9 December 2010

Director, Strategic Assessment  
Department of Planning  
GPO Box 39  
SYDNEY NSW

**Scottish Hospital, 2 Cooper St, Paddington - Paddington  
MP10\_0016 - Project Application for Seniors Housing and Care Facility - Exhibition**

803/40 Stephen Street, Paddington

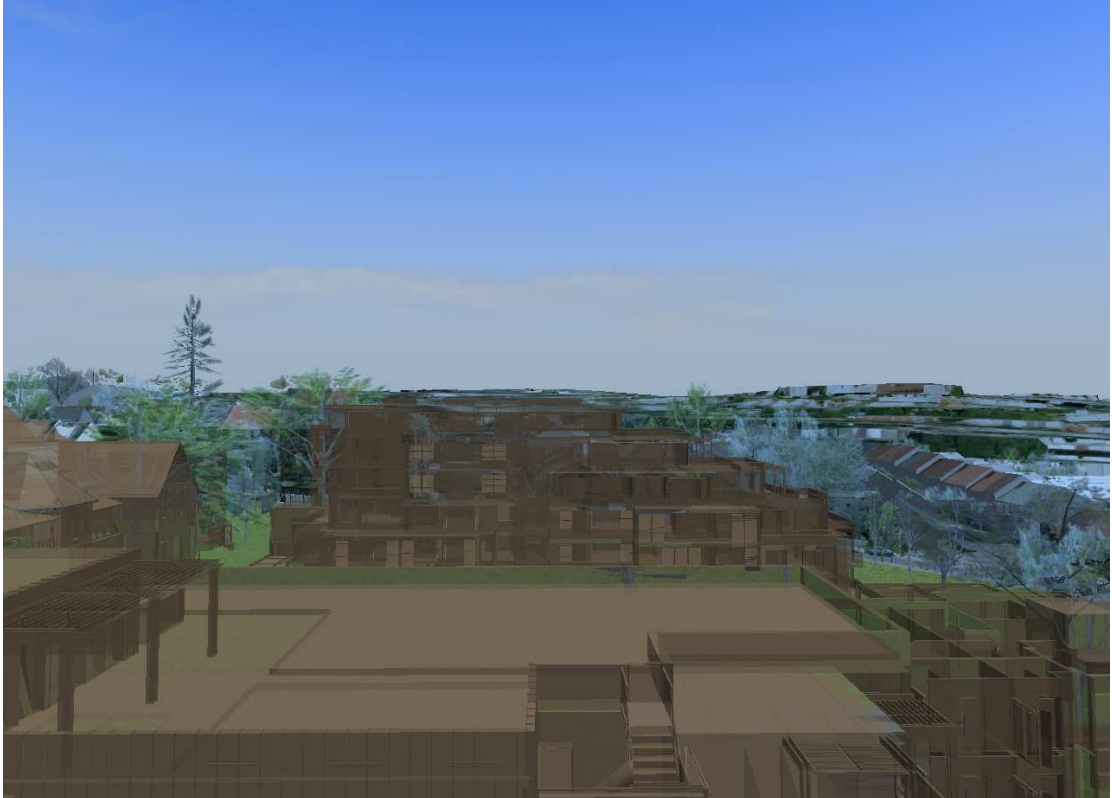
8. The view lines from Stephen Street (203-40, 401-40 and 803-40) clearly indicate the loss of vegetation cover involved with the construction of the six storey RACF building and the 5 storey Stephen Street Building. These buildings have such a massive footprint that only small replacement trees can be planted along Stephen Street. All of the trees along the Stephen Street frontage from Cooper Street to Glen Street are proposed for removal, many of which are large, mature trees. The buildings proposed are too large and too close to the streetline for effective landscaping. Three 3-D photomontage views clearly show the major impact on the landscape along the Stephen Street frontage (DA604 View 4 - StephenSt.pdf, DA605 View 5 - GlenSt.pdf, DA606 View 6 - GlennSt-Stephen.pdf). None of the major trees along the Stephen Street frontage should be removed and a ten metre setback should be established to protect these trees. The original gully line passed through this site and is the topographic feature which fosters the present luxuriant tree growth which provides ecological benefits and a corridor for fauna such as possums, bandicoots and birds in an otherwise densely populated urban area.
